Consultation Response from: KC Environmental Health (Pollution & Noise Control)		
2021/92427 - 48, Stile Common Road, Primrose Hill, Huddersfield, HD4 6DE		
Discharge conditions 9 and 10 on previous permission 2020/91228 for demolition of existing dwelling and erection of residential development to form student accommodation with associated access and parking		
Date Responded: 5th October 2021	Responding Officer: Natalie Heaney	Responding Ref: WK/202125277
Conditions 9 and 10 were recommended by the Coal Authority and relate to the Coal Mining legacy. Environmental Health were not originally consulted on previous permission 2020/91228. We acknowledge there is an overlap with Condition 9 as the coal mining legacy features may present an environmental health risk (e.g. from mine gases or combustion). Condition 10 relates to surface stability. This is outside the remit of Environmental Health. Condition 9 – Intrusive Site Investigation Works (Coal Mining Legacy) Environmental Health have previously provided comments on the following documents: • A Coal Investigation report by Rogers Geotechnical Services Ltd, dated 10th June 2021 (ref: C337/20/E/1956). • An Addendum titled ‘Gas Monito

Section A-A

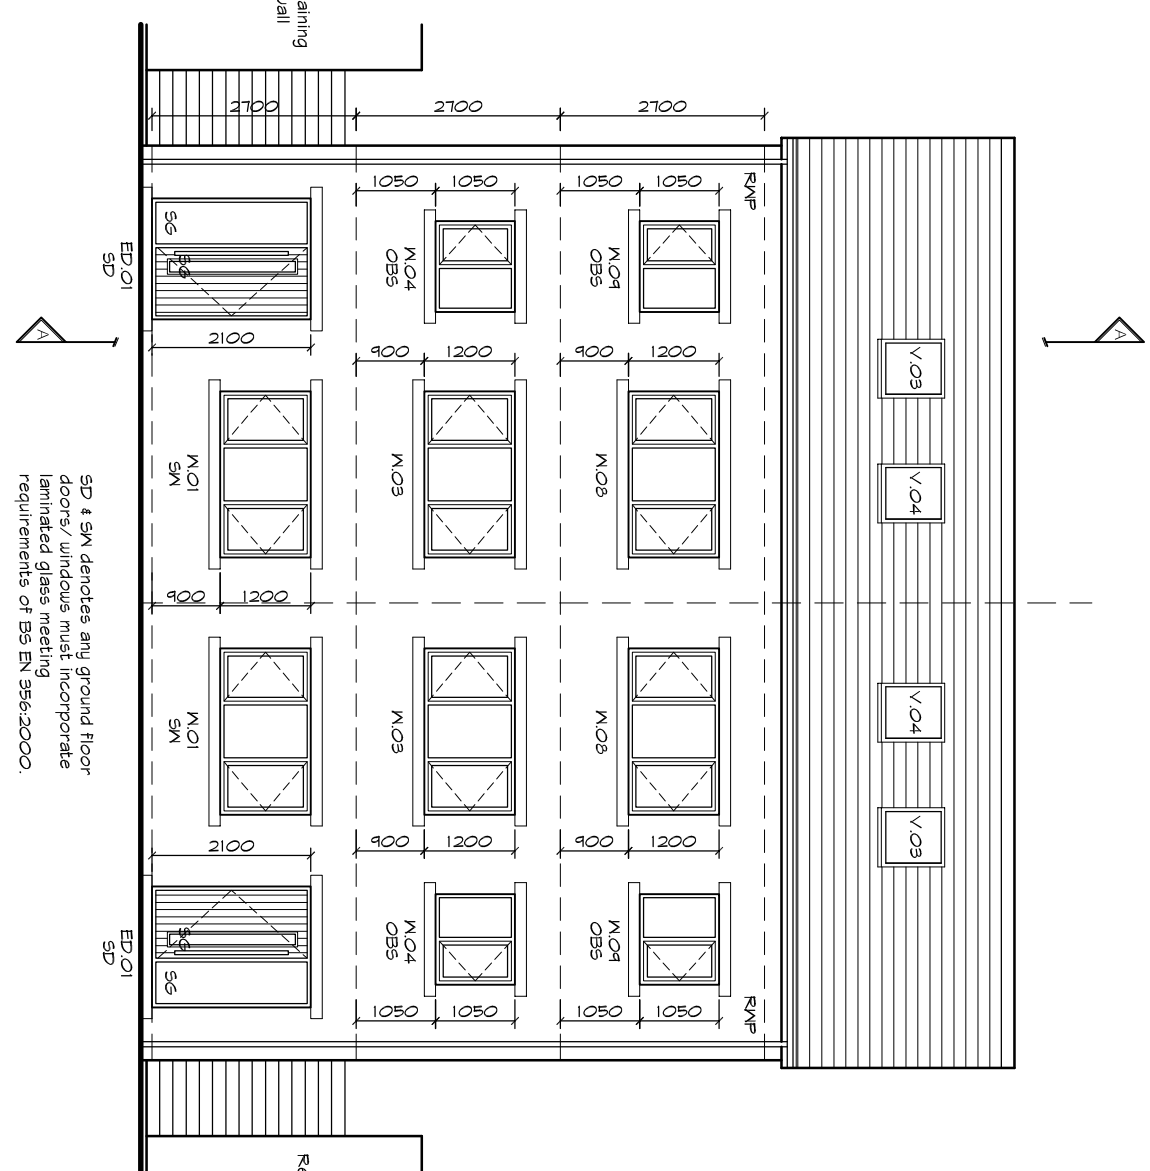
We also note the proposals for the installation of Characteristic Situation Level 2 gas protection which is considered in the email as reasonable protection from ground gases given the very low concentrations of gas and flow rates recorded.

As deeper ground conditions were only confirmed in one location, we have concerns that the provision of backfilled material may give rise to horizontal migration of gas that has accumulated in deeper workings to off-site sources. In the absence of a full assessment of all potential pathways, it is unclear whether this would remove all potential risks. We also cannot accept the proposals for gas protection elements for a Characteristic Situation 2 (CS2) site as it would be unclear without further work, whether CS2 protective elements would be suitable for the proposed development. For instance, the site could fall into CS3, in which case CS2 measures would be inadequate.
